Department of Transportation

June 18, 2020

RE: Liberty Tree Academy Site Dev Plan - PPR2018

Memorandum

**Figure 1  
VICINITY MAP**

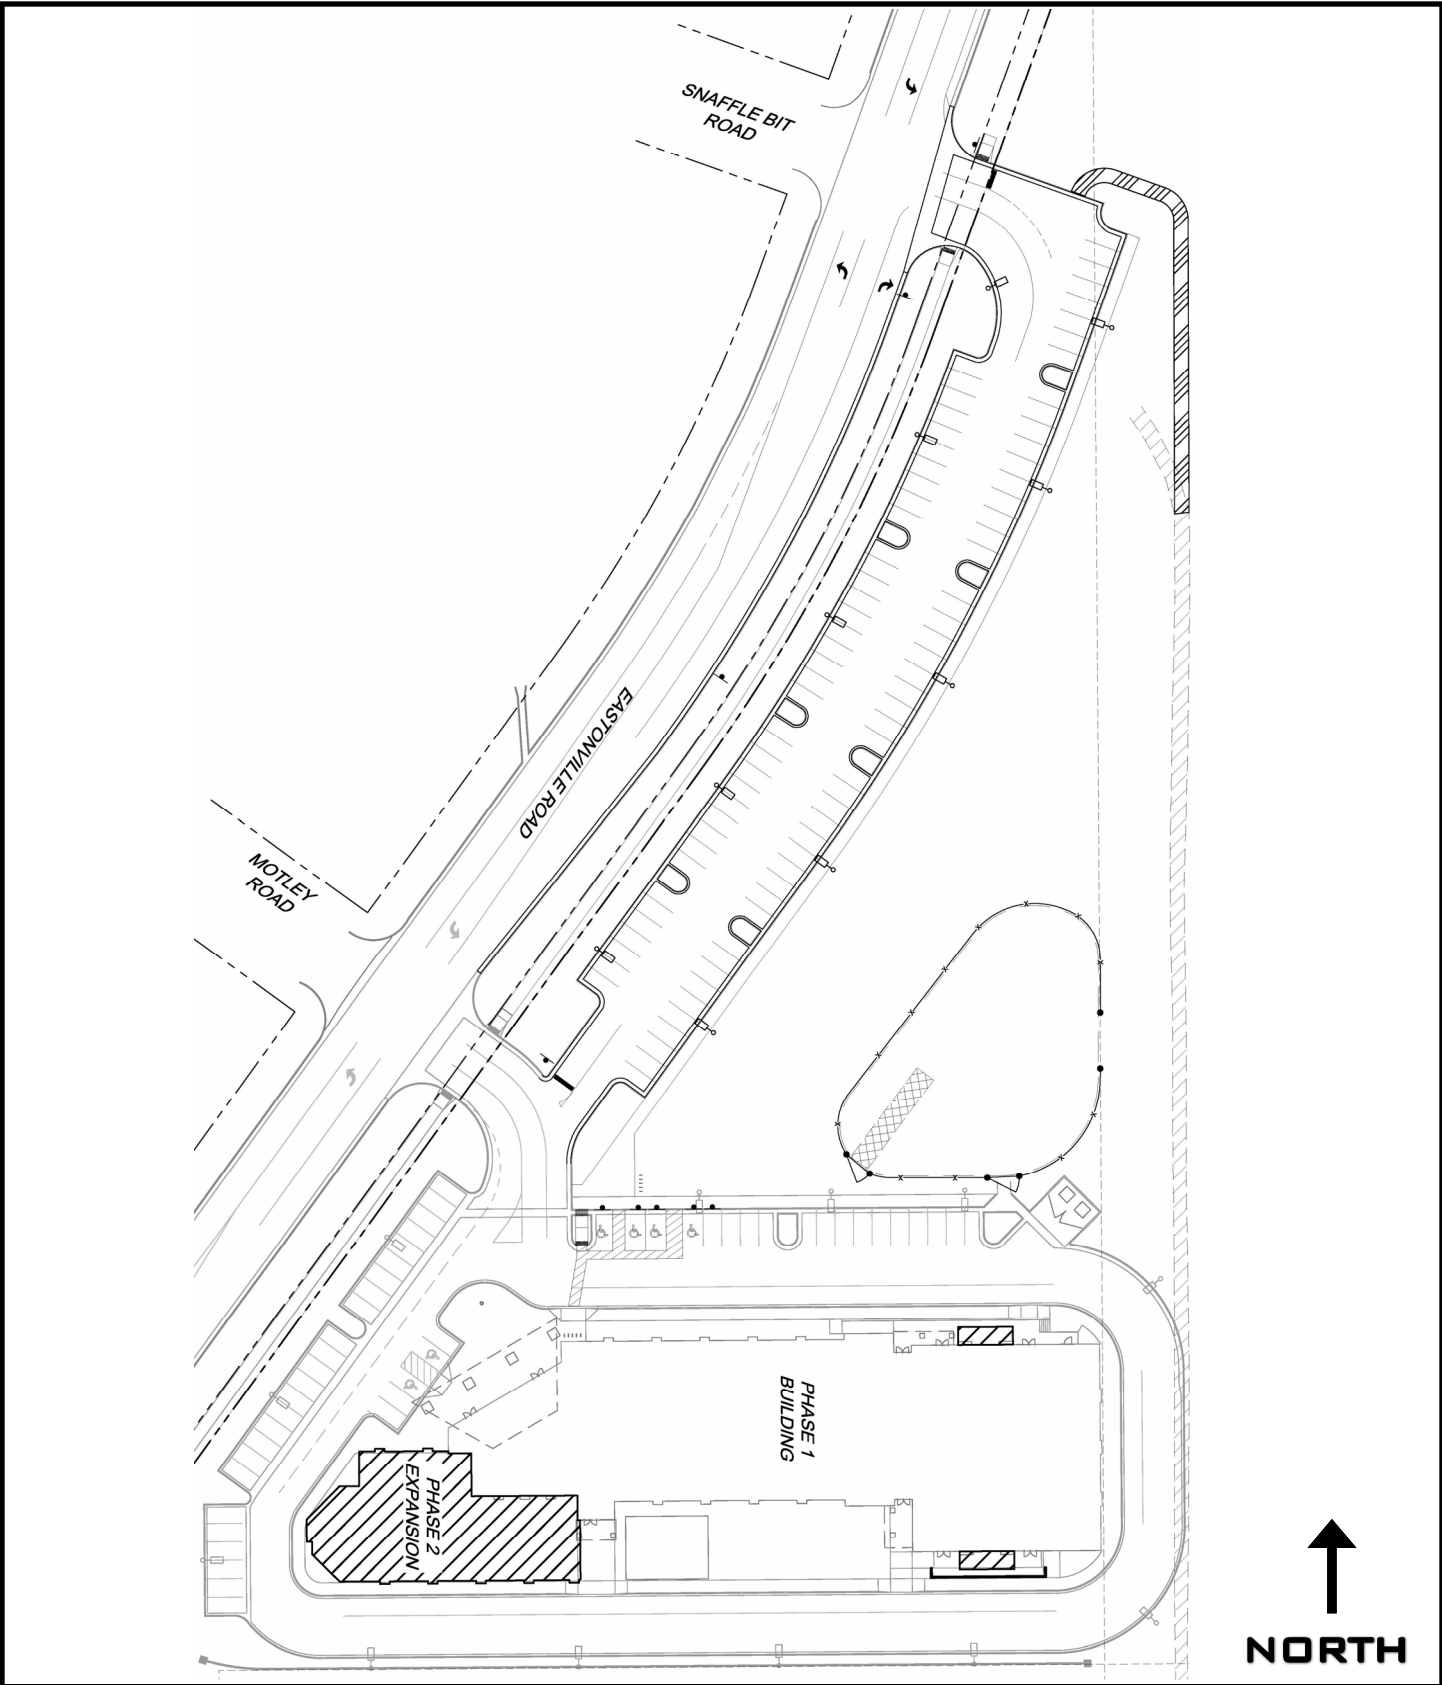
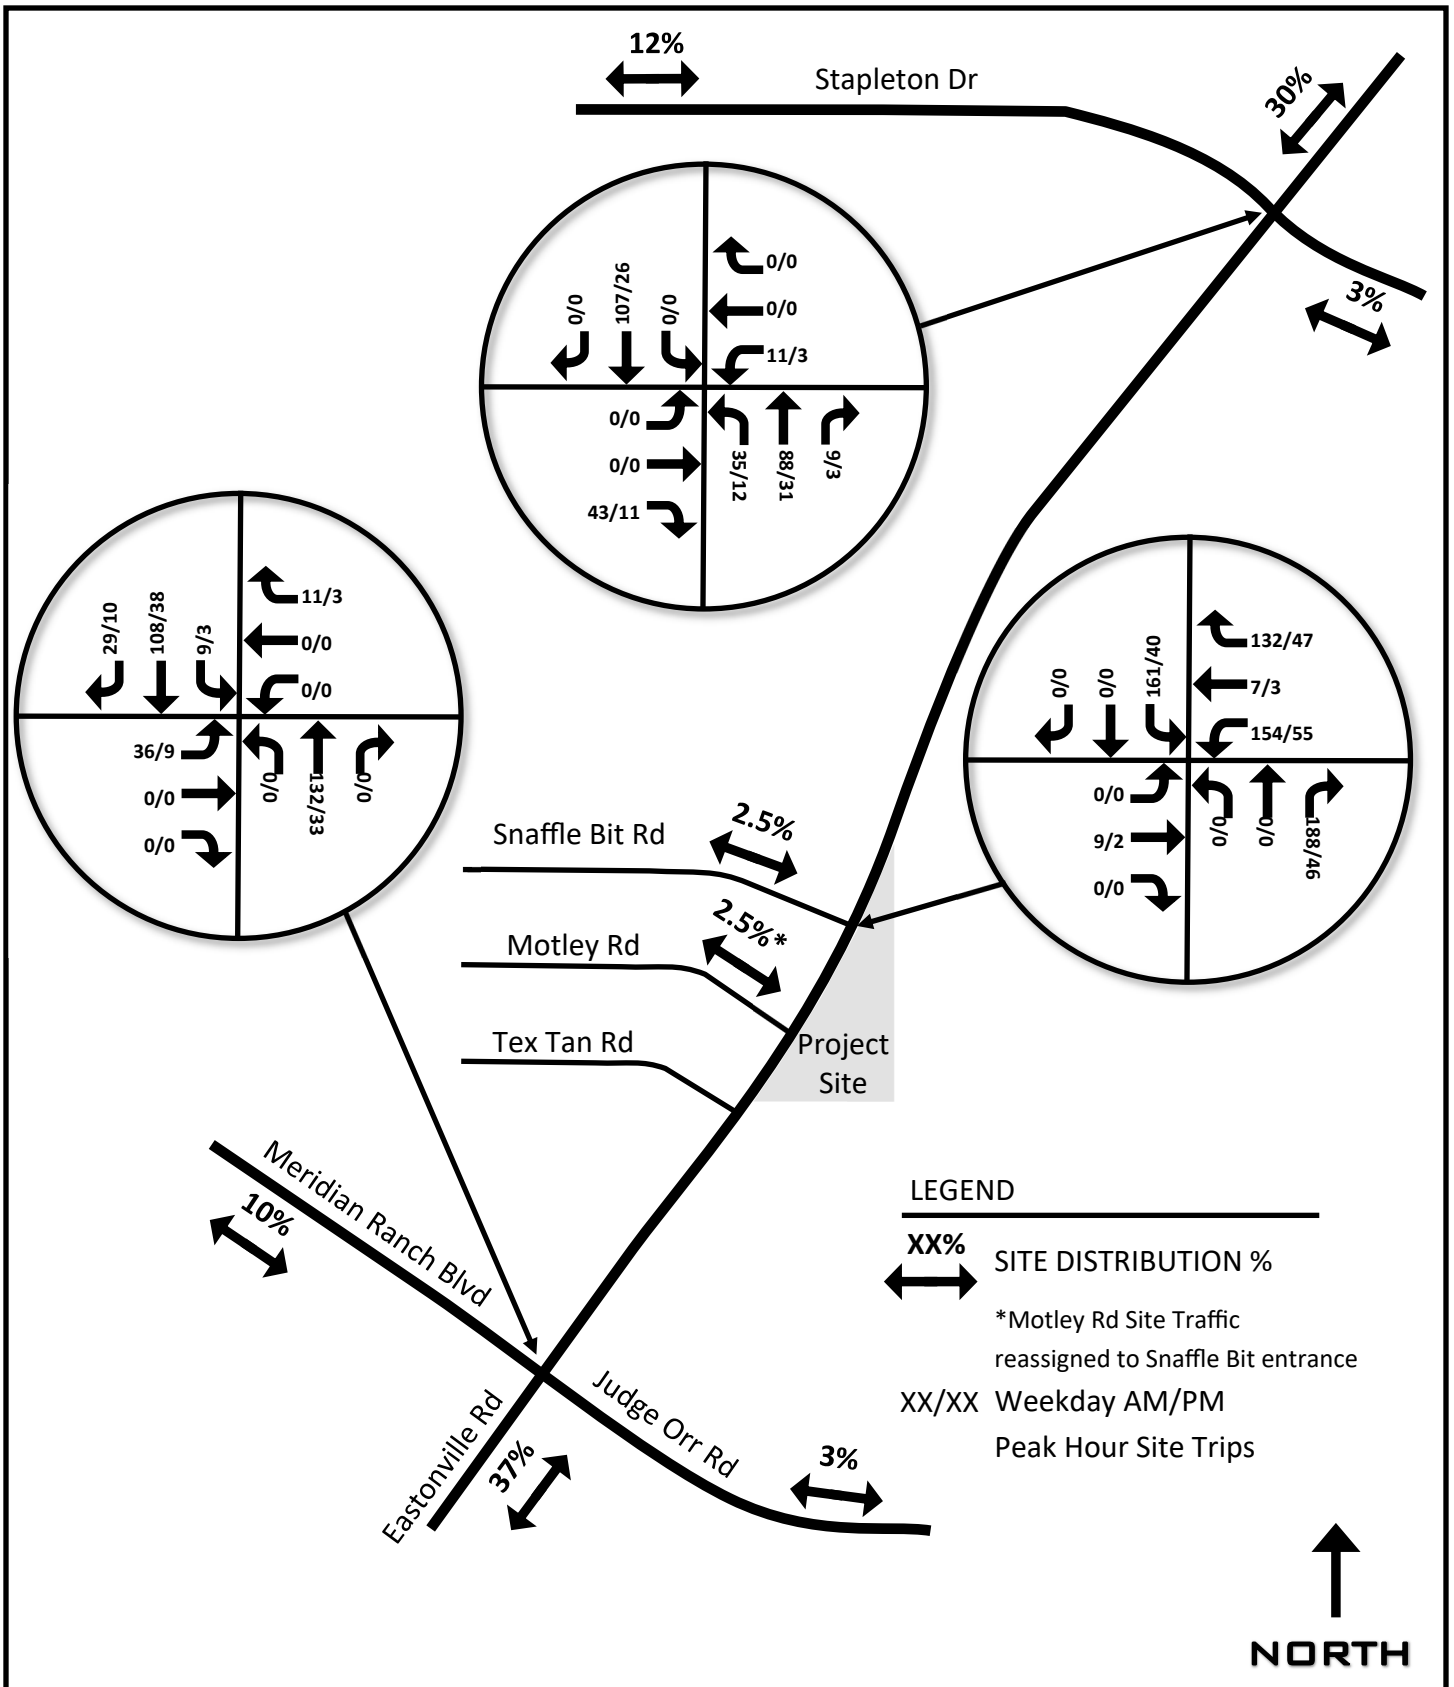
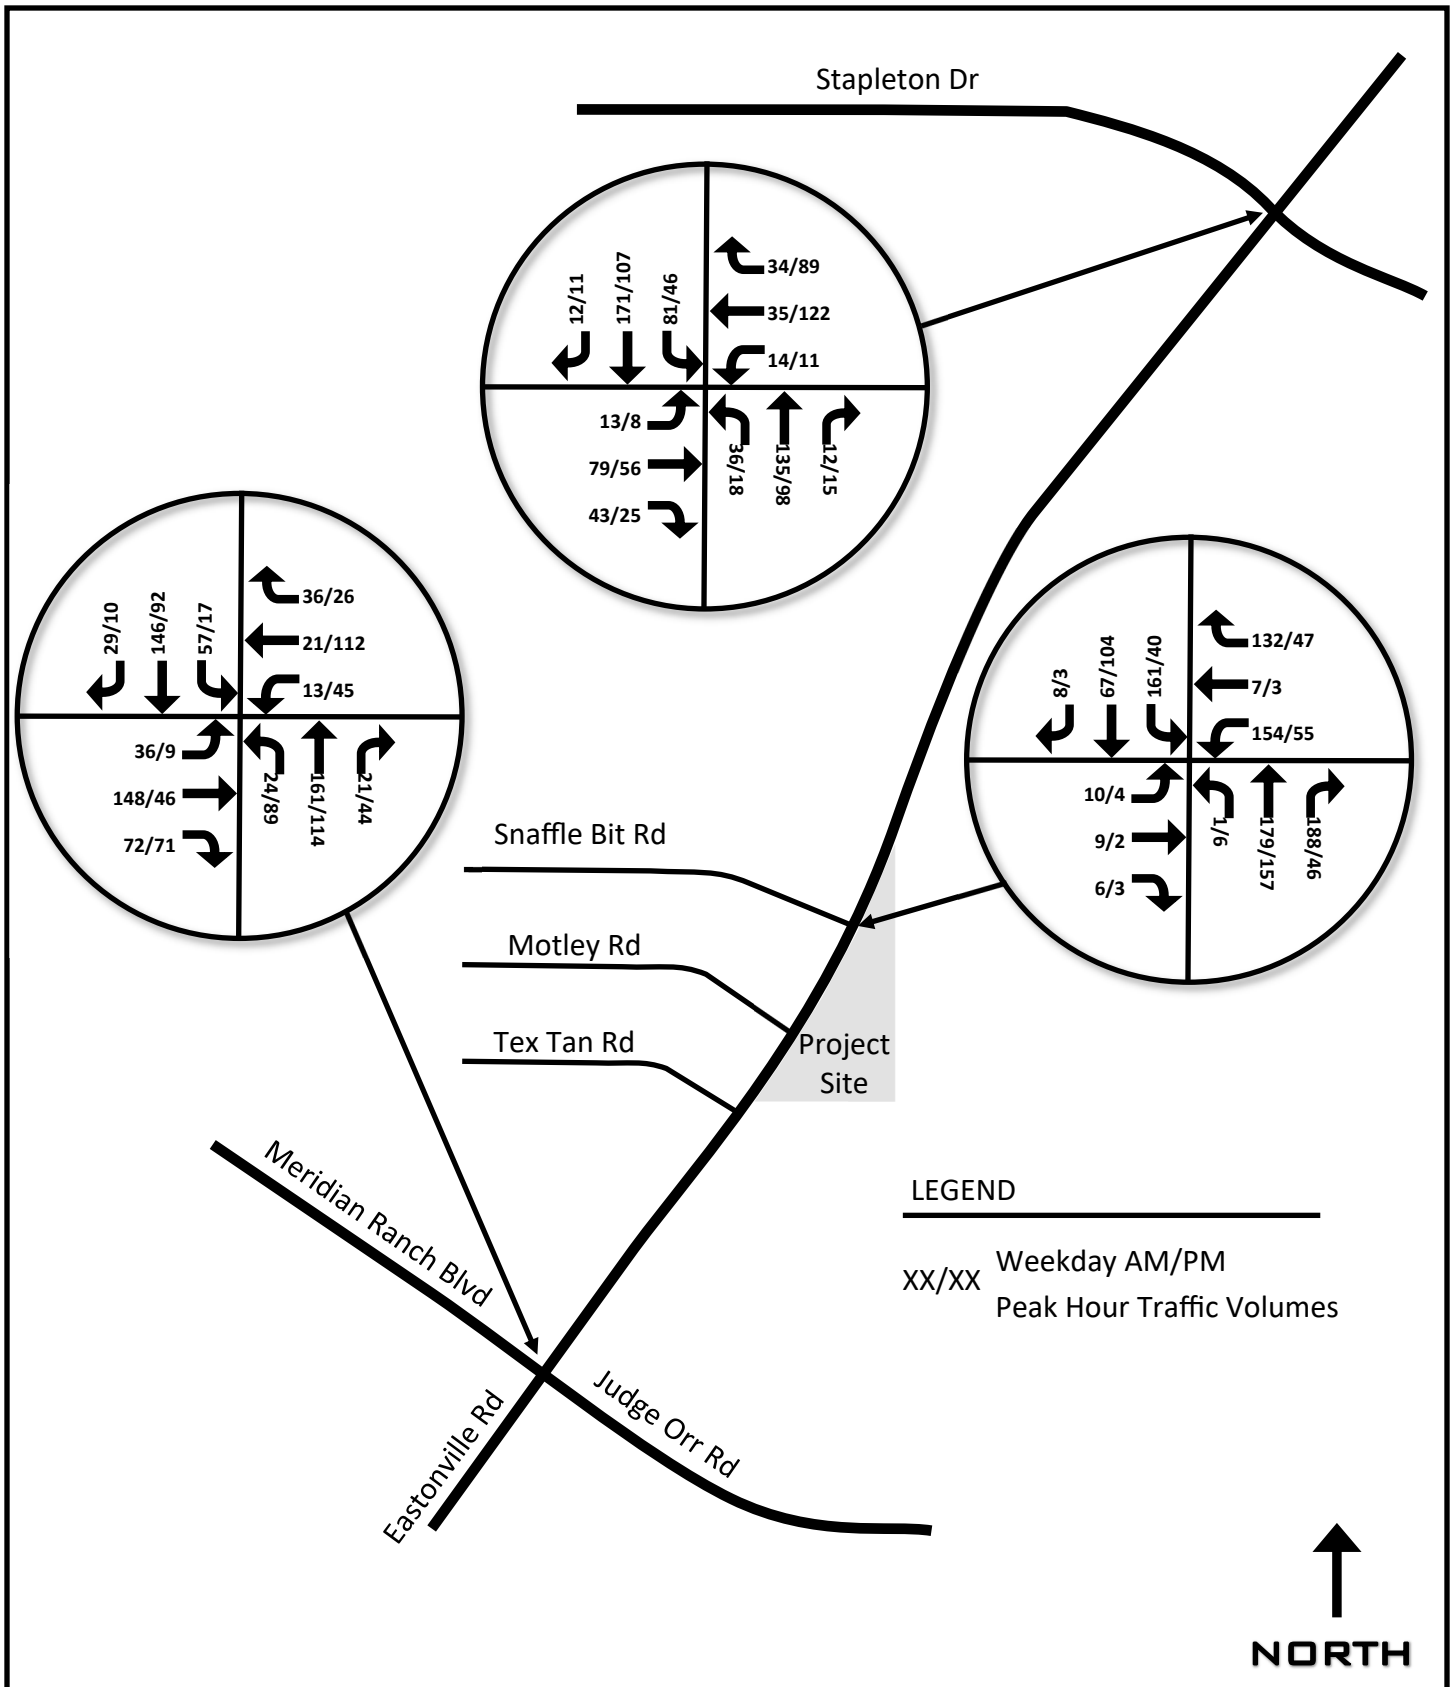
Please provide an exhibit of this phase 2 circulation plan.
